KITTITAS COUNTY

MEMORANDUM

TO: All Staff
FROM: Public Works Plan Review Team
DATE: November 9, 2021
SUBJECT: LPF-21-00011 Black Horse Phase 1

DRAWN BY: B.S./P.T./J.K./C.F./R.G. | SHEET 13 OF 15

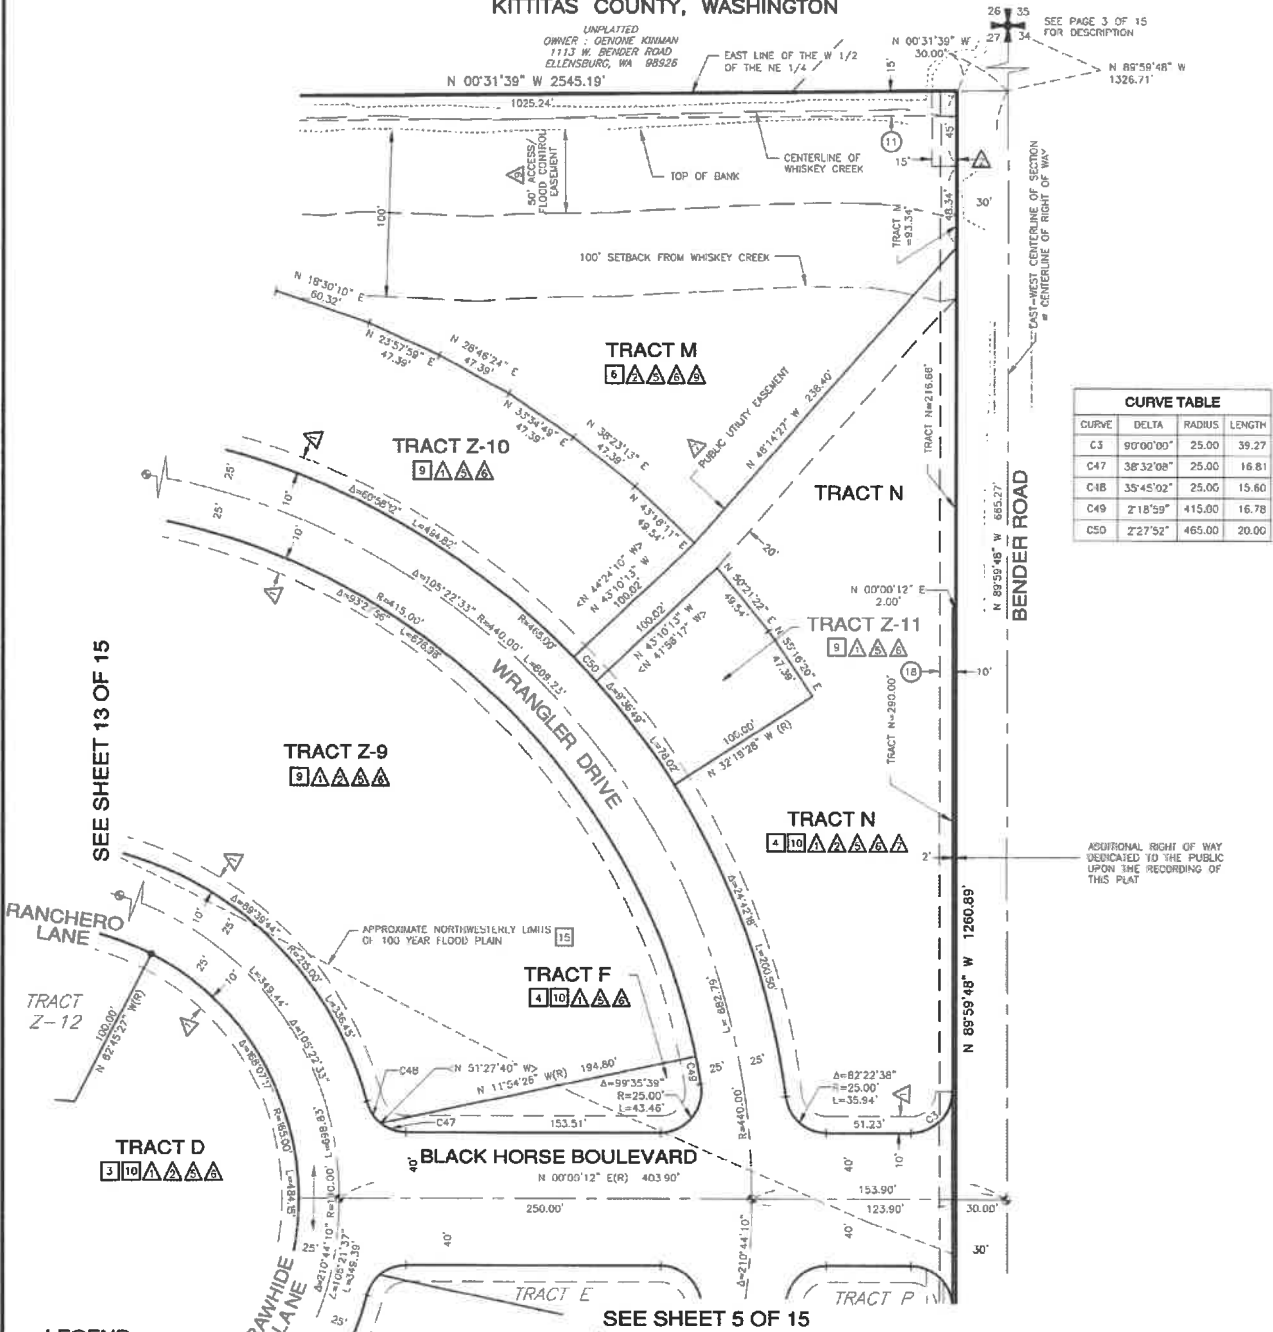
Sheet 13

1. The NE'most dimension of Wrangler Drive does not match Sheet 12. (Shown as L=168.04, R=425.00, D=22°39'15")
